One Earth Solar Farm

**Draft Statement of Common Ground with Newark and
Sherwood District Council**

EN010159/APP/8.6.1

July-August 2025

Figure 11.1: Site Location and Study Area

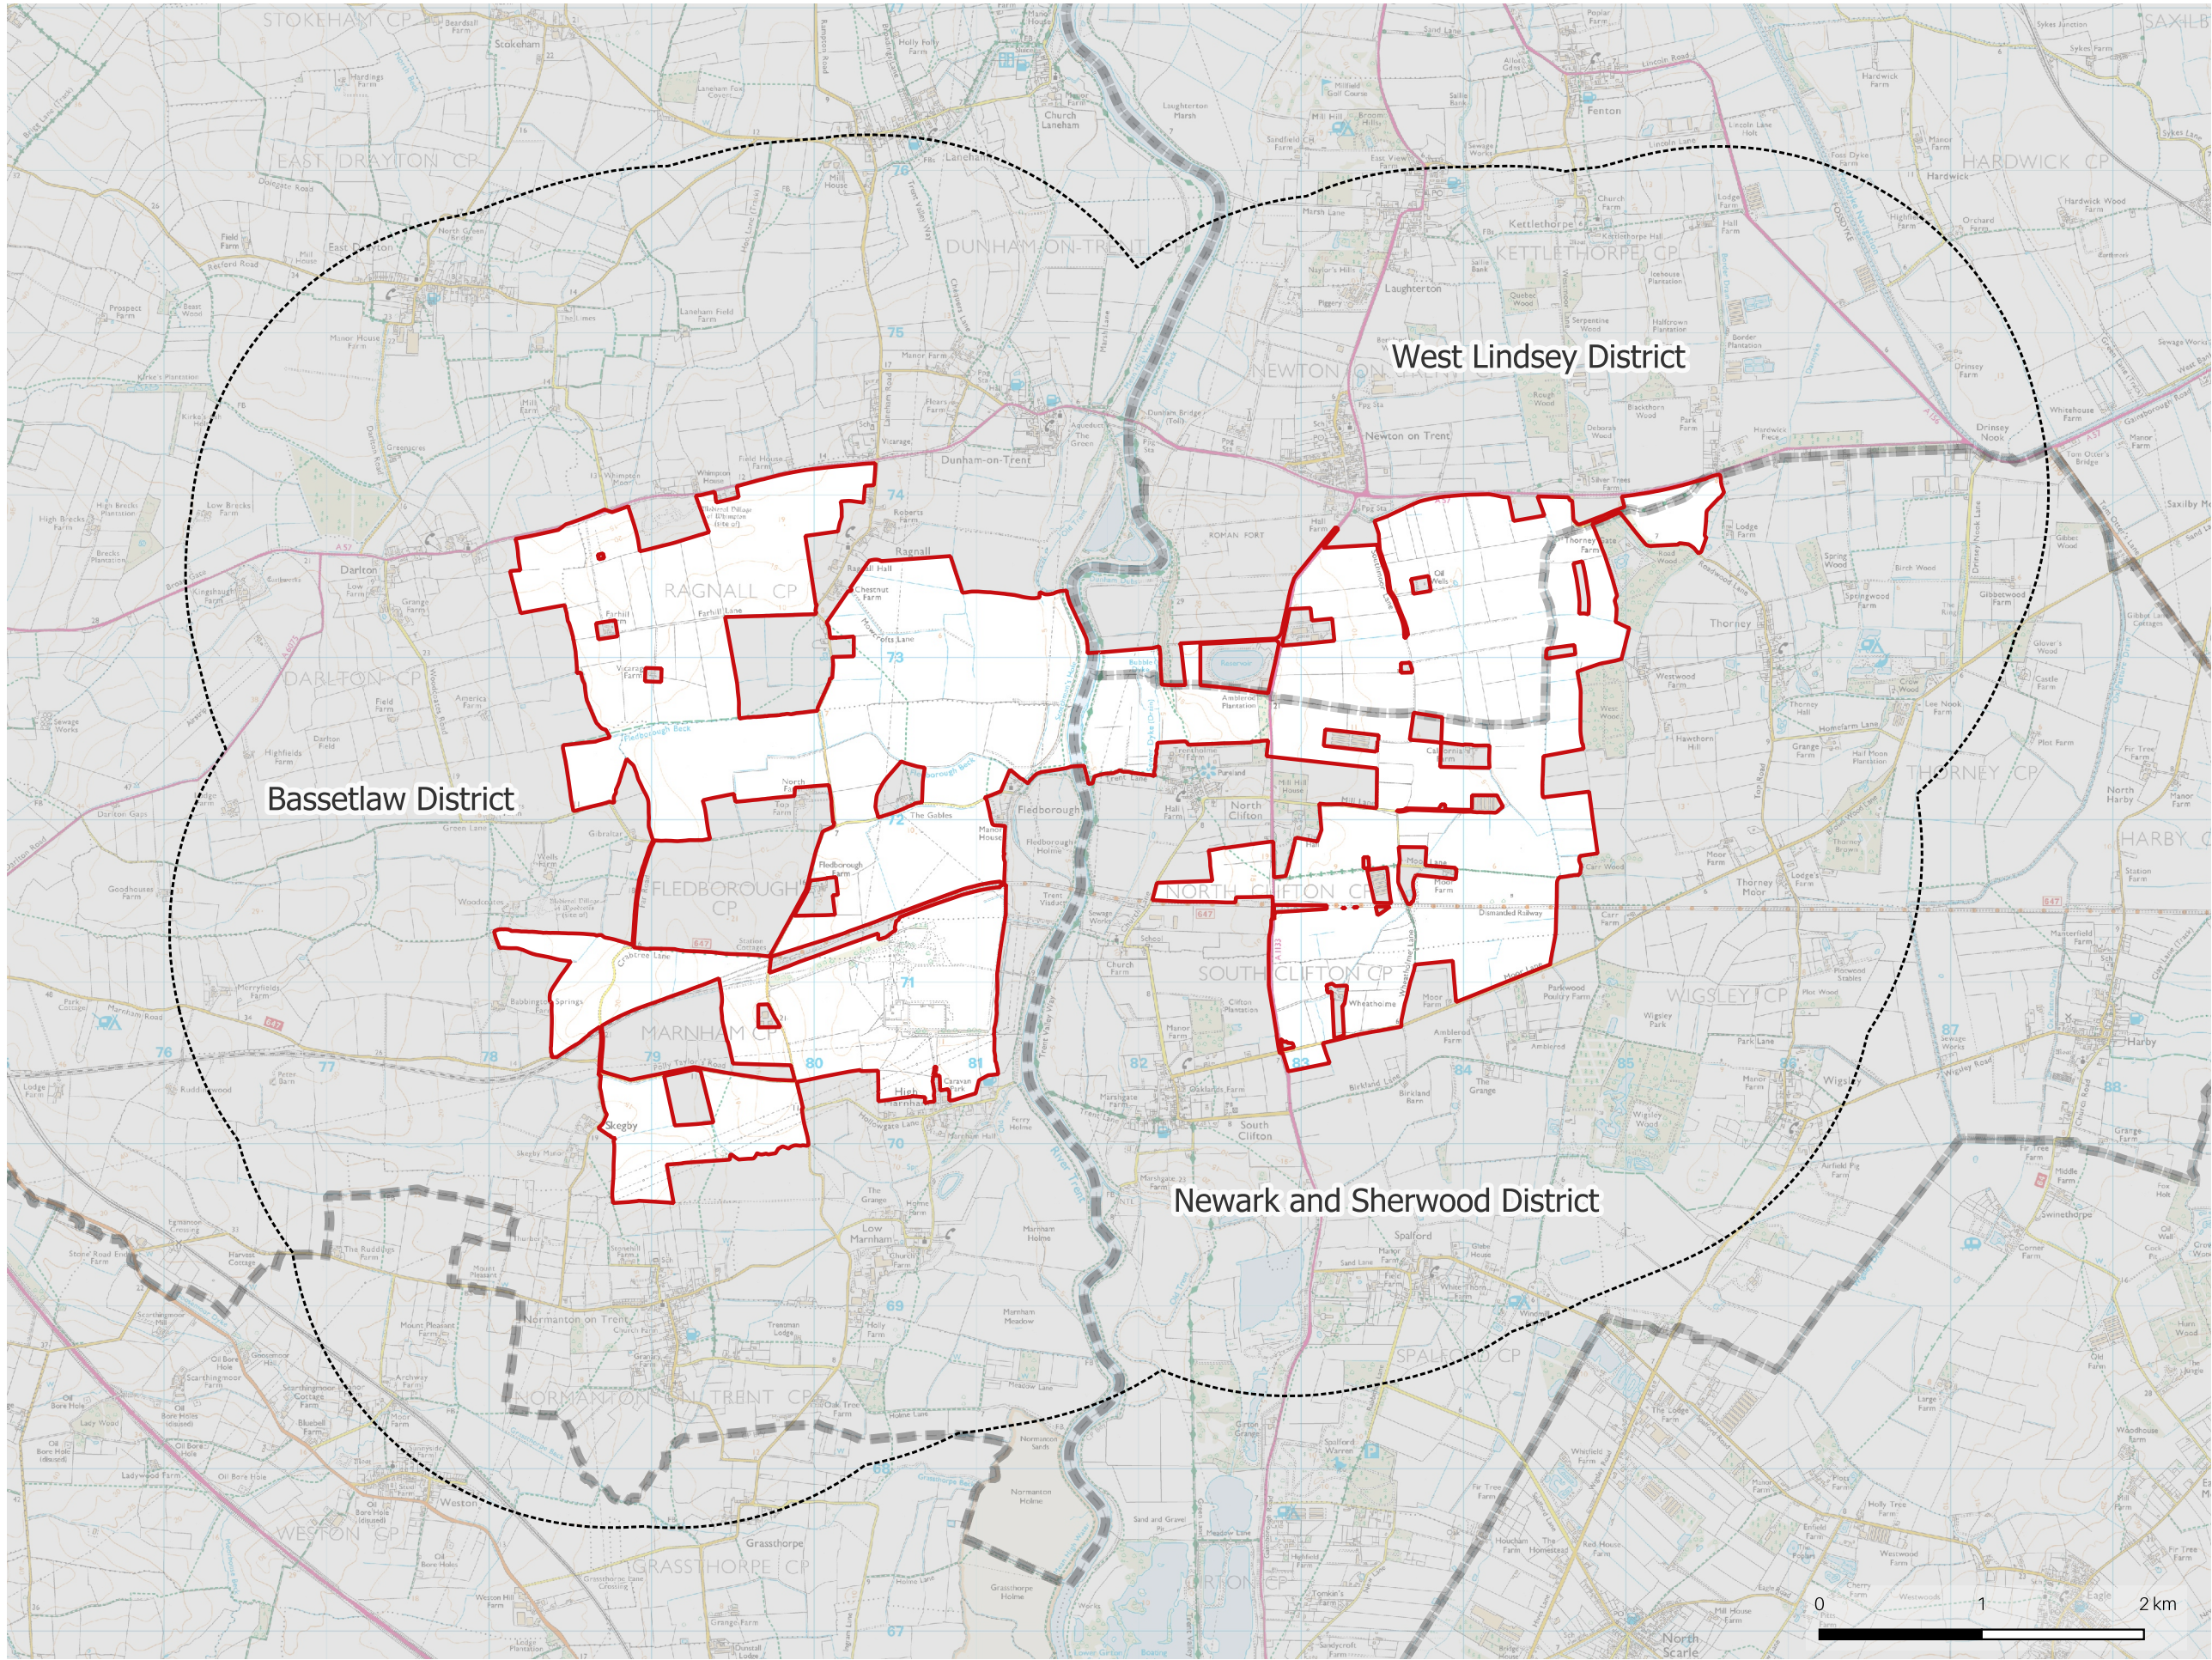
| 04-02 | LVIA Study Area | <p>AAH Consultants commented that effects beyond 2km had not been considered fully at the PEIR as all the proposed viewpoints were located within the 2km LVIA Study Area, despite the ZTV showing the potential for visibility beyond 2km.</p> <p>In response, photographs from 8 locations were provided by the applicant to test the judgement of no significant visibility beyond 2km.</p> <p>AAH Consultants welcomed these photographs but questioned the location of some of them in terms of representativeness of the receptor.</p> | The LVIA 2km Study Area is agreed following a site visit between the applicant and AAH Consultants on 25 th June 2025 which included visiting several of the locations of the supplementary photographs previously provided, confirming that they are representative. | Agreed |

Drawing file: published-documents / EN010159-000302-6.20 Environmental Statement Volume 3 - Figures 11.9 Local Village Character Areas.pdf

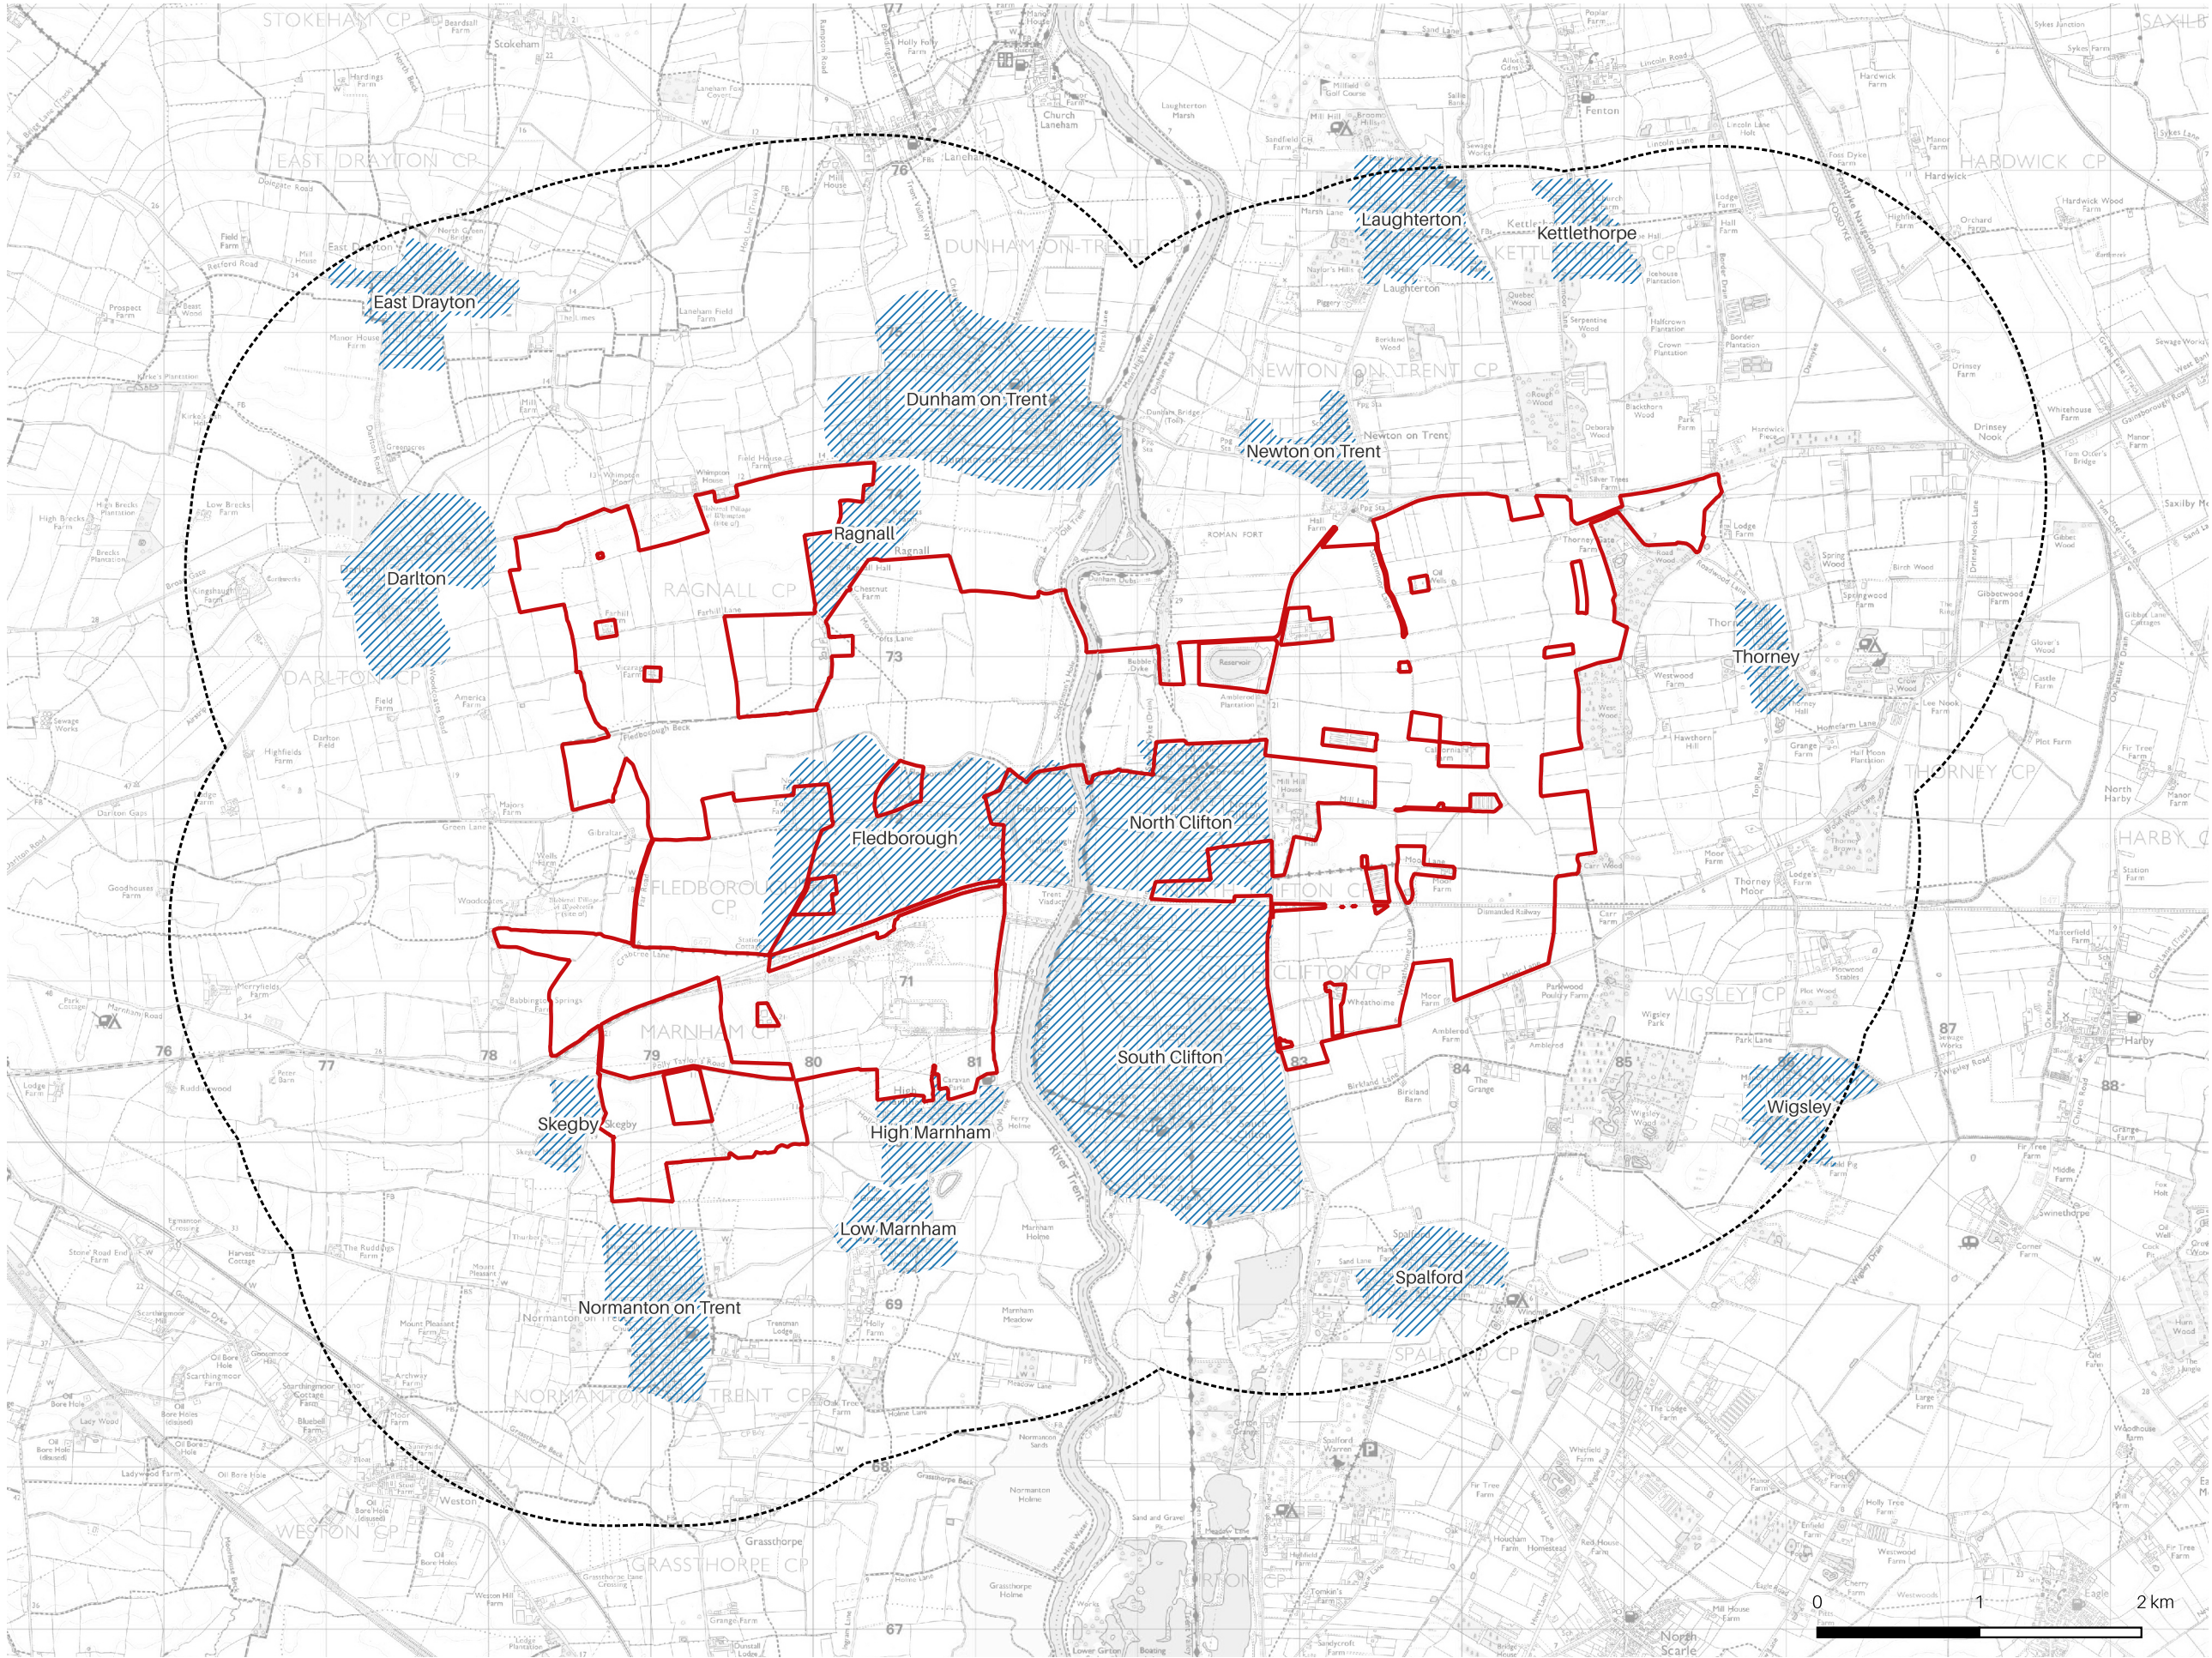
| 04-03 | Scope of landscape receptors | <p>The inclusion of Thorney as a Local Village Character Area following feedback on the PEIR was welcomed.</p> <p>No further comments or concerns on the scope of landscape receptors have been raised to date.</p> | <p>The scope of landscape receptors is agreed.</p> <p>The scope of landscape receptors was updated in the LVIA ES Chapter to include for the suggested additions and refinements.</p> | Agreed |
